AH/220010/L0004

18th March 2022

**On behalf of Kier PGIM Logistics Propco 1 Limited, Saltbox, Bognor Regis:
Non-material amendment to planning permission BE/135/18/PL (as previously amended by
BE/125/21/NMA) - Alterations to approved external appearance and roof of Units 6 & 7**

Drg No **KP-281-Units 6/7-NMA-02**

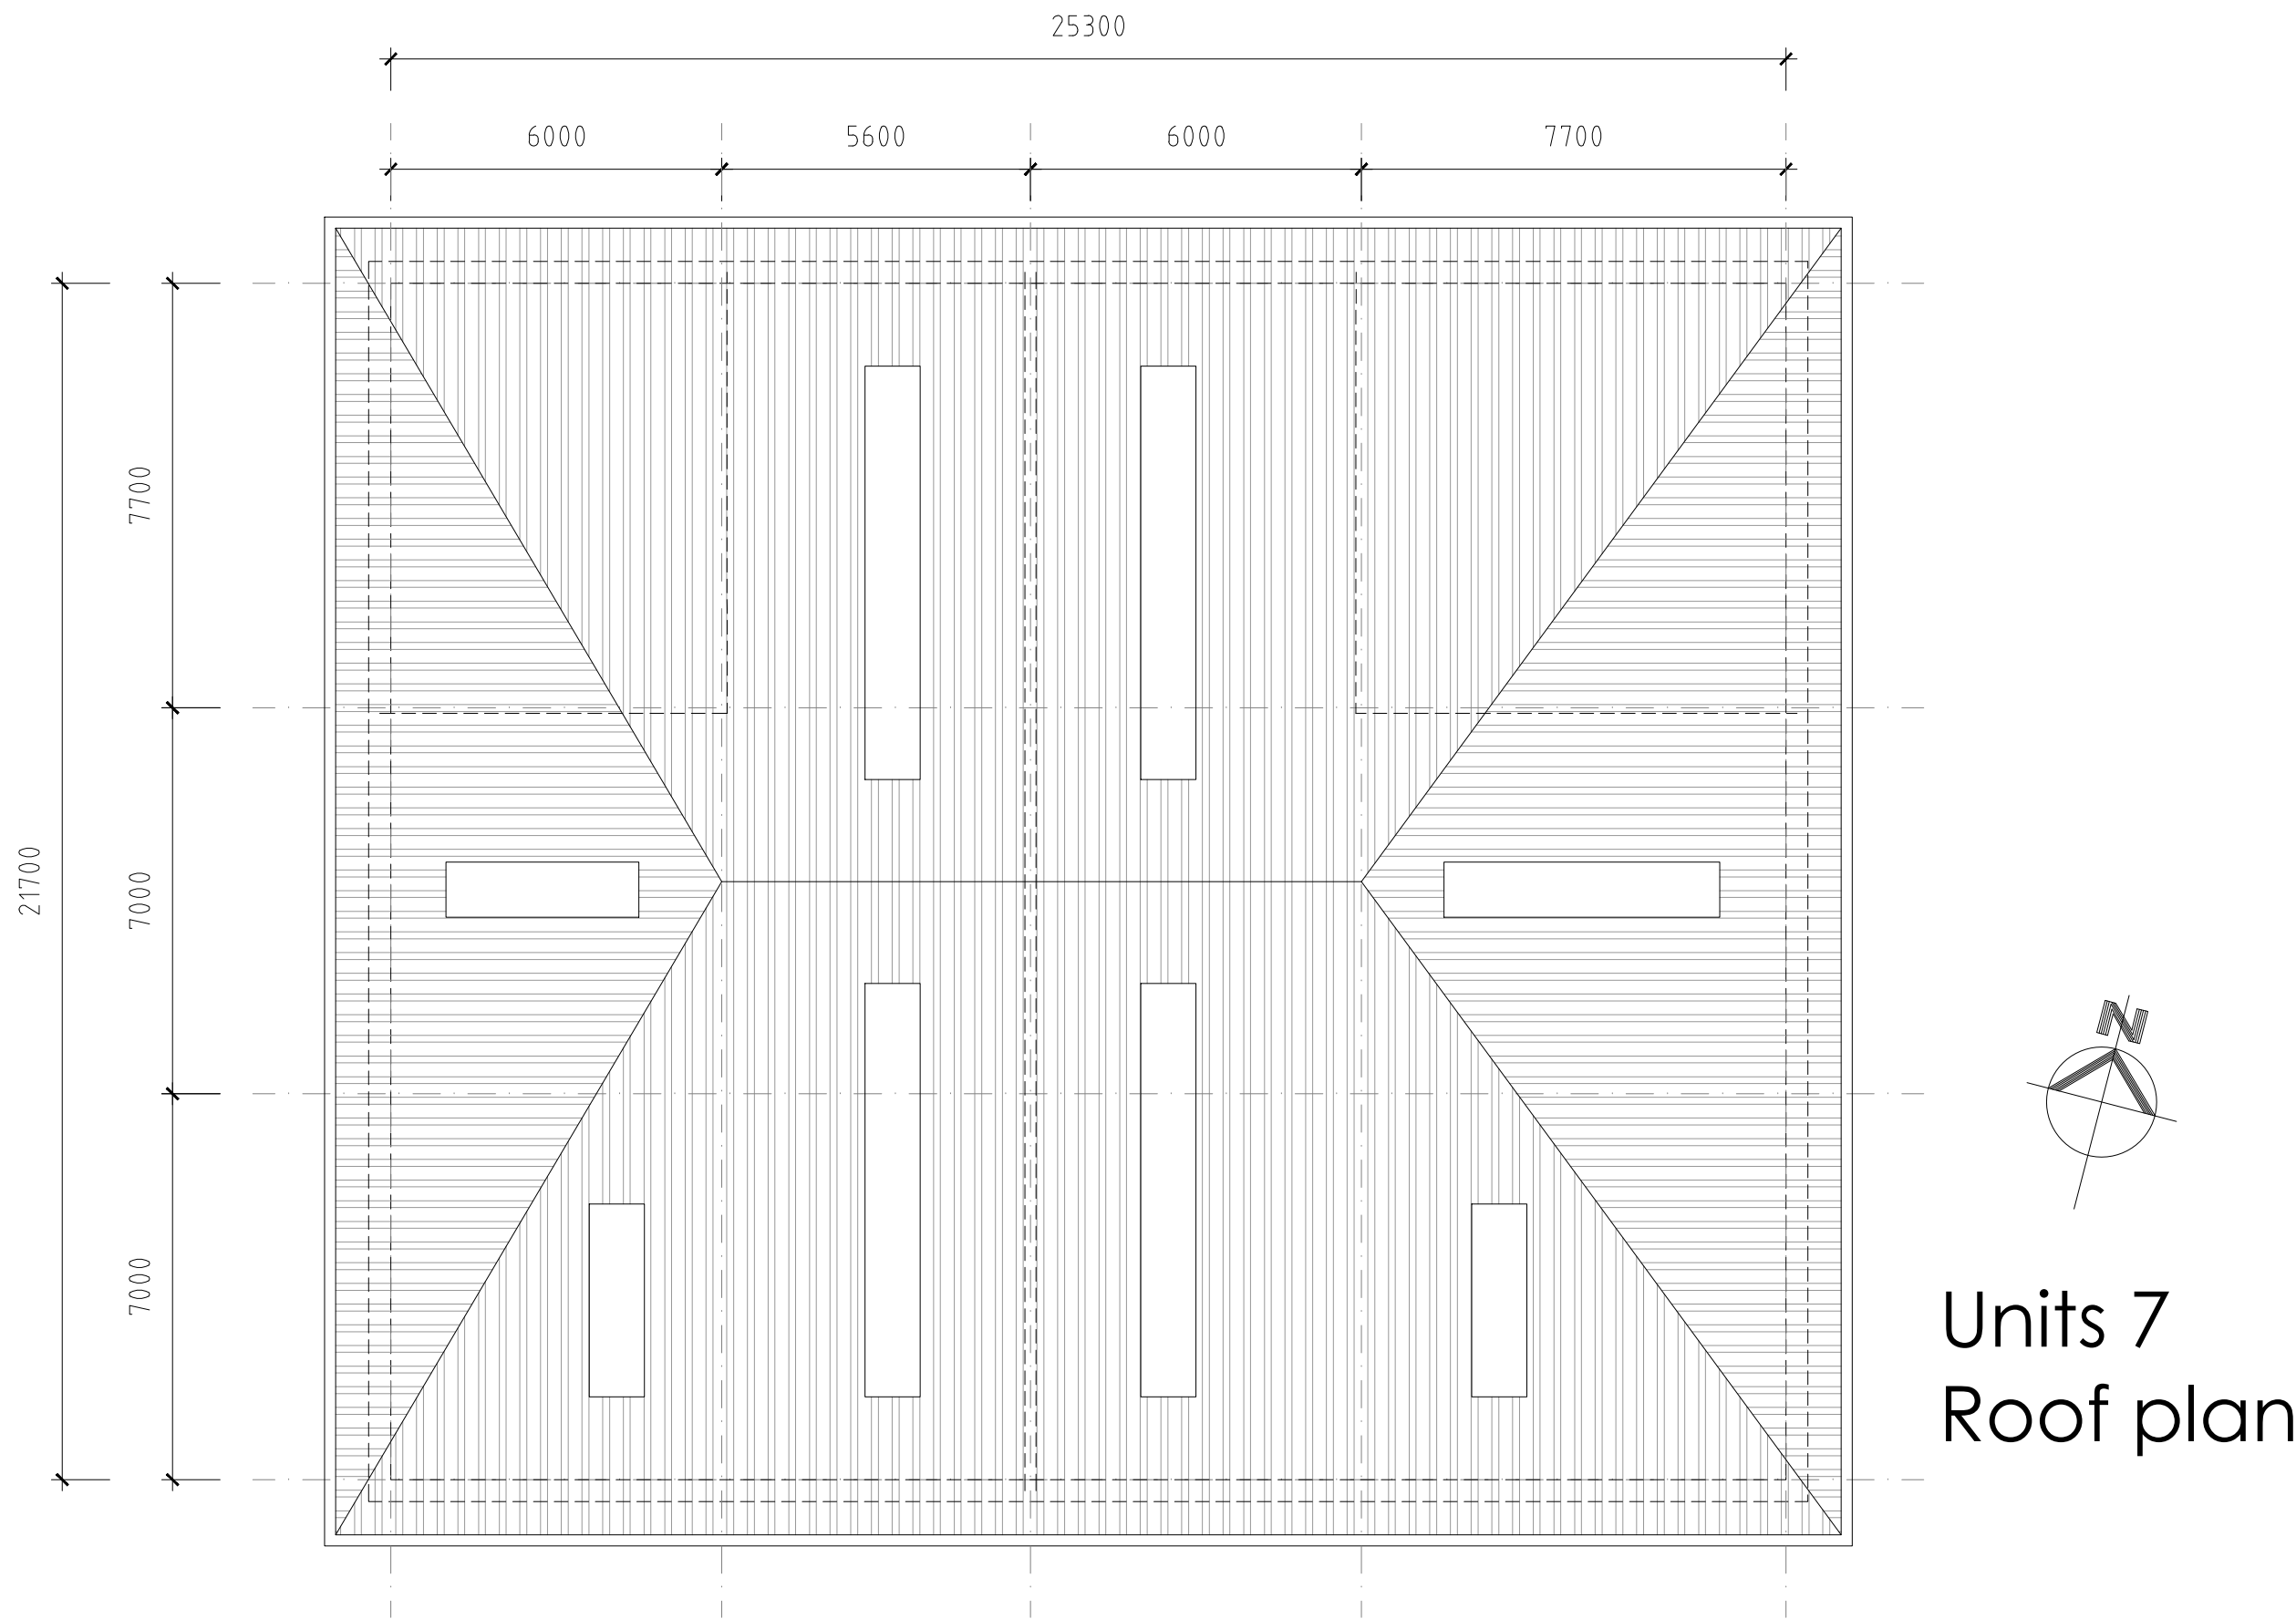
The detail of the change sought is shown on the enclosed drawing KP281-Units 6/7-NMA-02 prepared by Ian King Associates. This shows revisions to the elevations of Unit 3 in response to the requirements of the intended tenant and changes to the associated materials to correspond with Kier's specification for the site.

A minor change is also proposed to the roof to incorporate hip features at the western and eastern ends. This will add interest to the building's appearance and will also serve to reduce its overall scale and massing.

No changes are proposed to the site layout, scale or dimensions of the approved building.

The above drawing, if approved, will be in substitution of approved drawings 1744-TU-P04B (Proposed Roof Plan) and 1744-TU-P05C (Proposed Elevations). These are the latest approved drawings for the unit under the previous NMA (Ref BE/125/21/NMA dated 10th August 2021). which added 42 sq m of solar to the roof. The units will continue to accommodate the intended 42 sq m of PV on the roof.
